Recommendation Report for Planning Permission for Works or Extension to a Dwelling

REF NO: M/77/21/HH

LOCATION: 43 Lane End Road
Ancton
Middleton-On-Sea
PO22 6LT

PROPOSAL: Conversion of garage to habitable use and alterations to fenestration

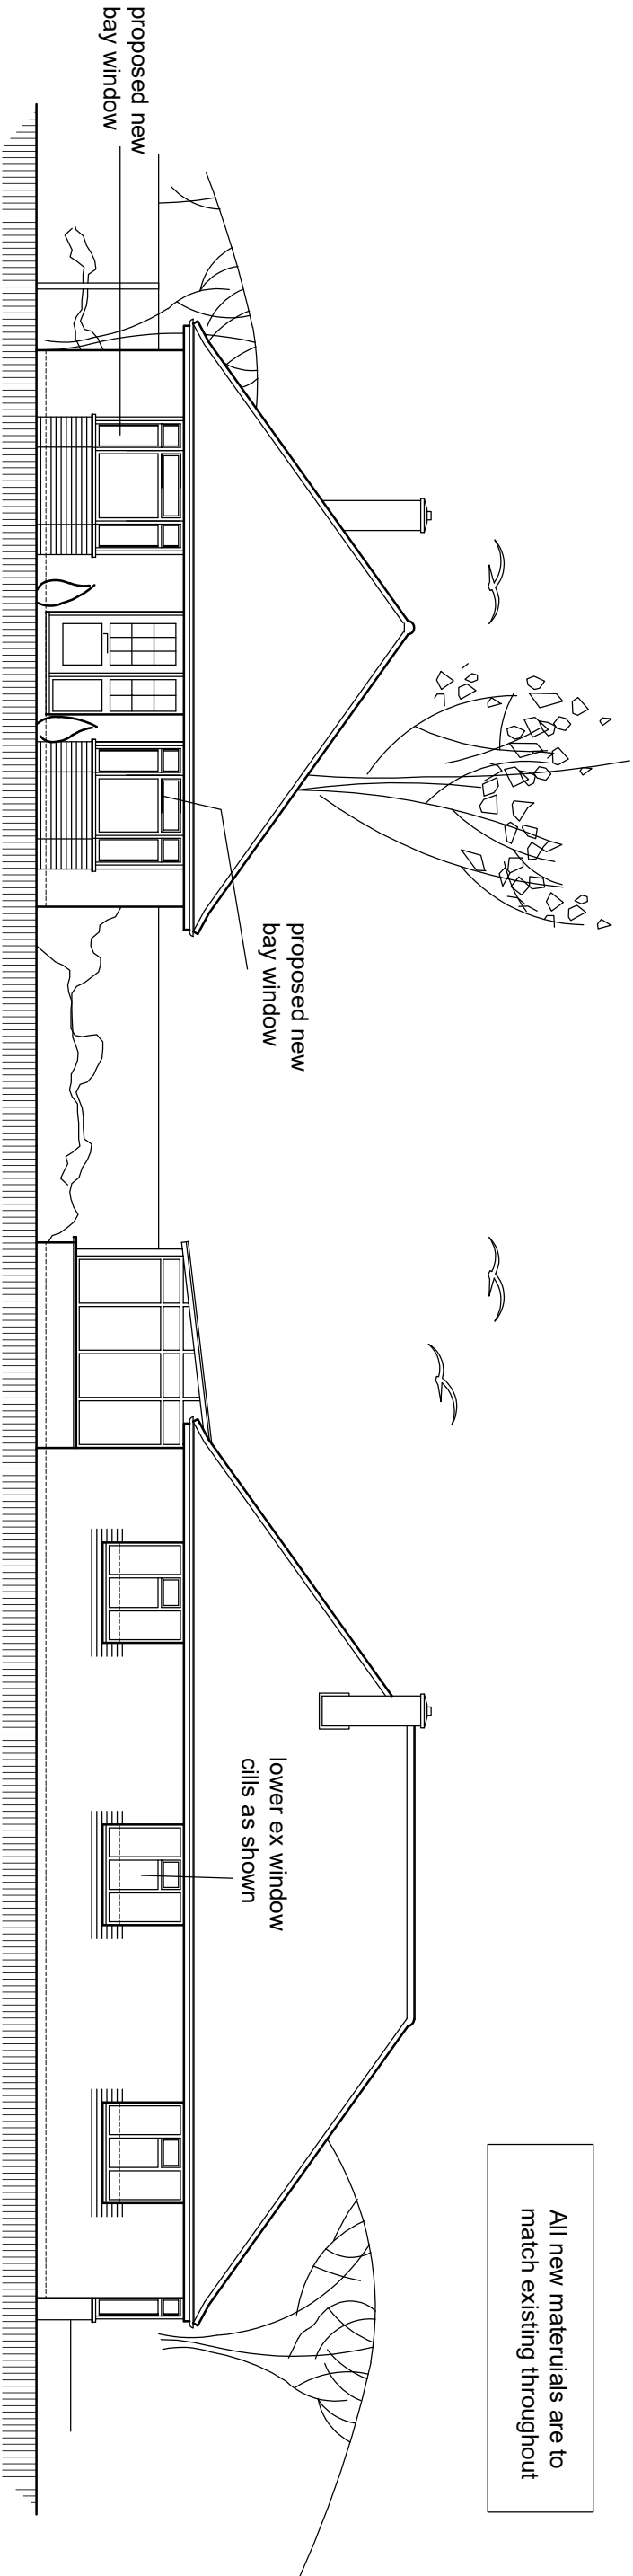
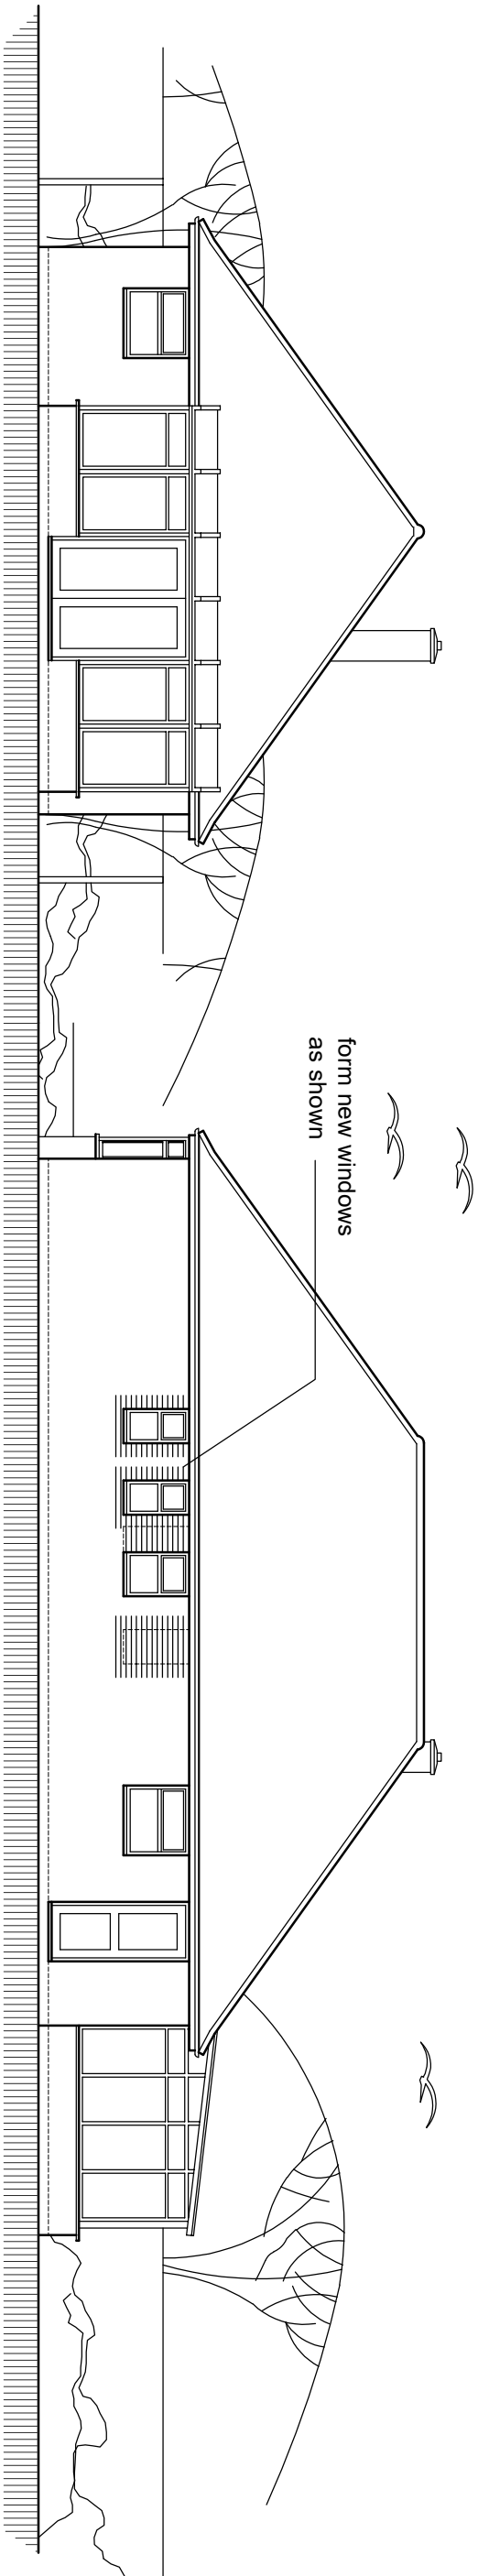
At the front elevation there will be a new window and the garage door will be replaced with a window for the study.

At the side (north) elevation there will be a new window.

The windows which will be replaced or added will not result in any overlooking to neighbouring properties due to the single storey nature of the property and the face that some of these windows are pure replacements only.

The conversion of the garage to habitable use will not result in any harmful impacts to the area. The garage door will be replaced by a window which will not cause any harmful impacts to Lane End Road.
